Subject: AL/141/21/RES Lees Yard

I've been reviewing the Reserved Matters submission. I have the following requests for further information:

Drawing Name Landscape Strategy

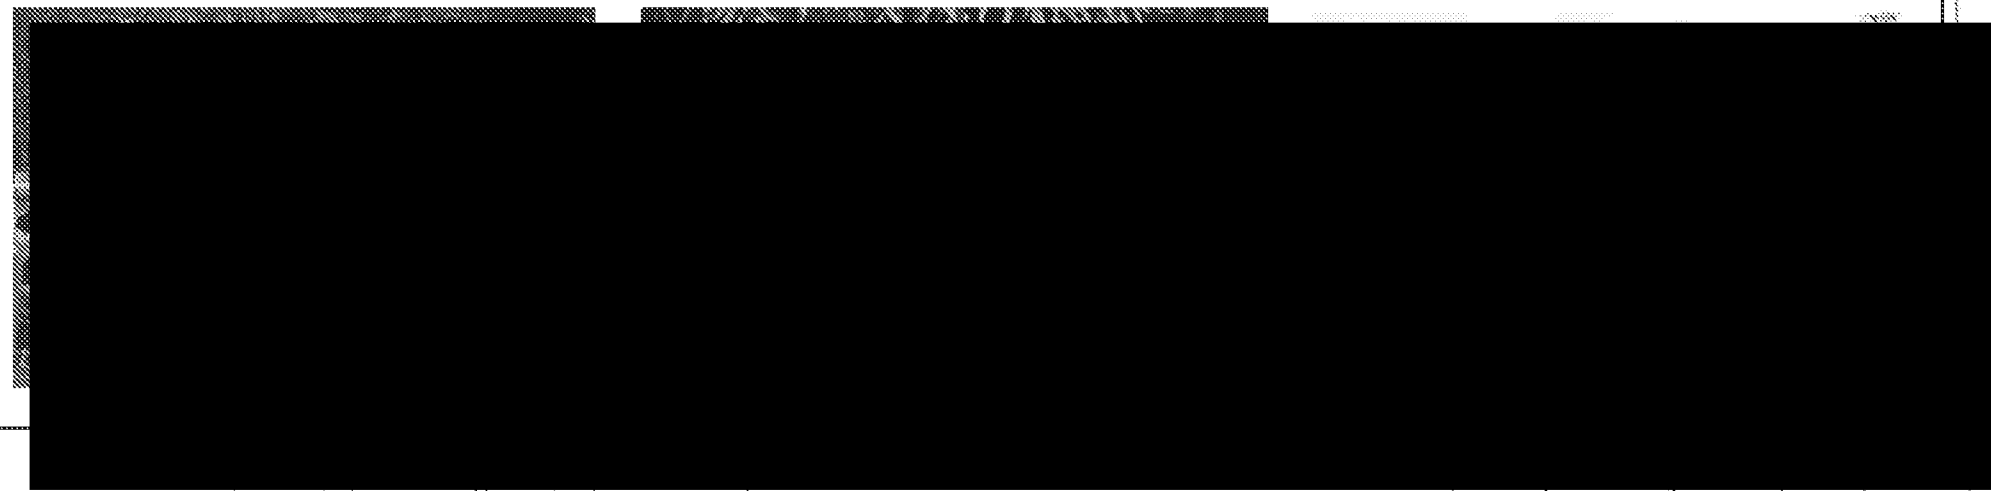
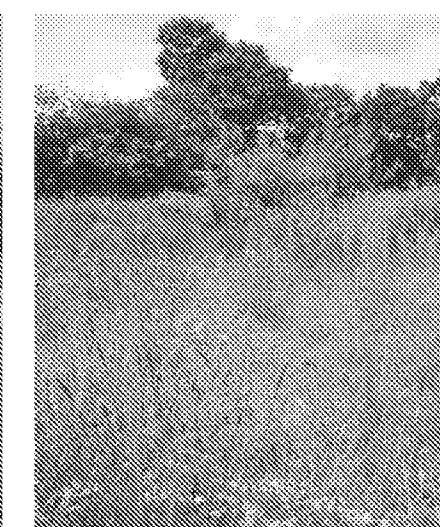
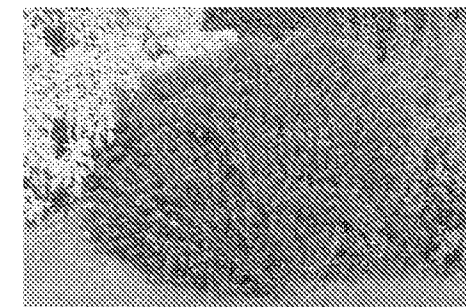
- We need full details of new landscaping as this is a reserved matter but we only have a strategy plan at present. I also have a concern that some of the street trees shown within the layout (particularly where adj to plots 15 & 19) don't have room to grow.

Job No/Drawing No			Job Title
21452/6003.1A			Lee's Yard, Woodgate
Scale	Date	Drawn	Drawing Title
1:100	11/21	PK	C3H3-P_Plans
@ A3

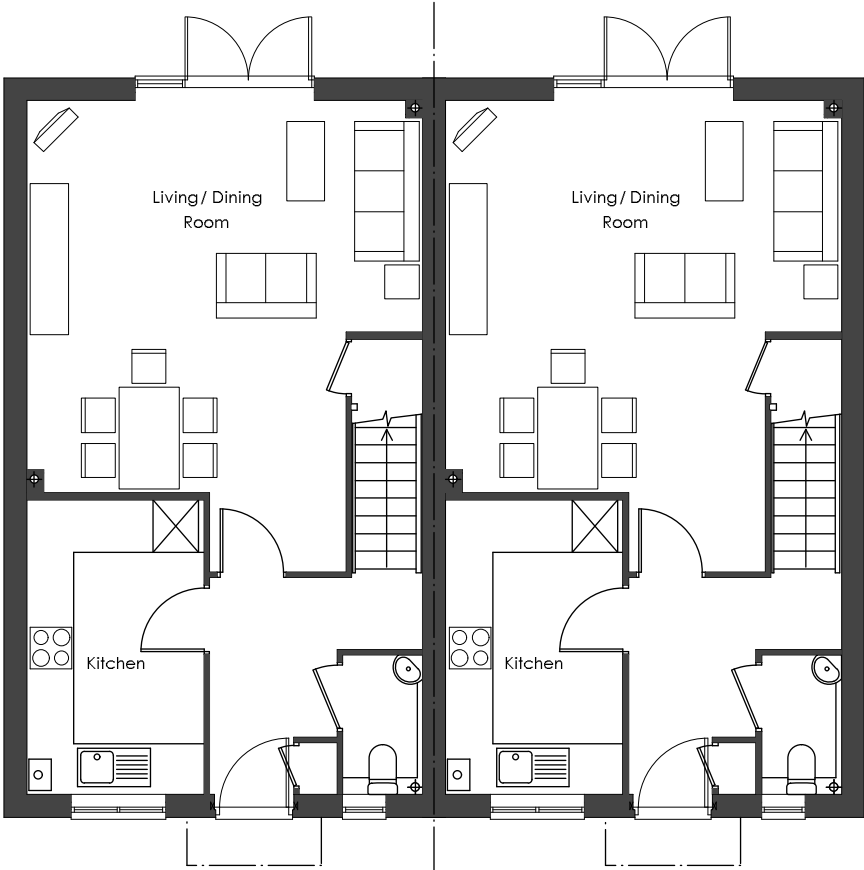
- I am having an issue scaling from the floor plans. They state 1:100 at A3 but I am getting measurements too low. For example, using this scale, double beds are only 1.4m long.
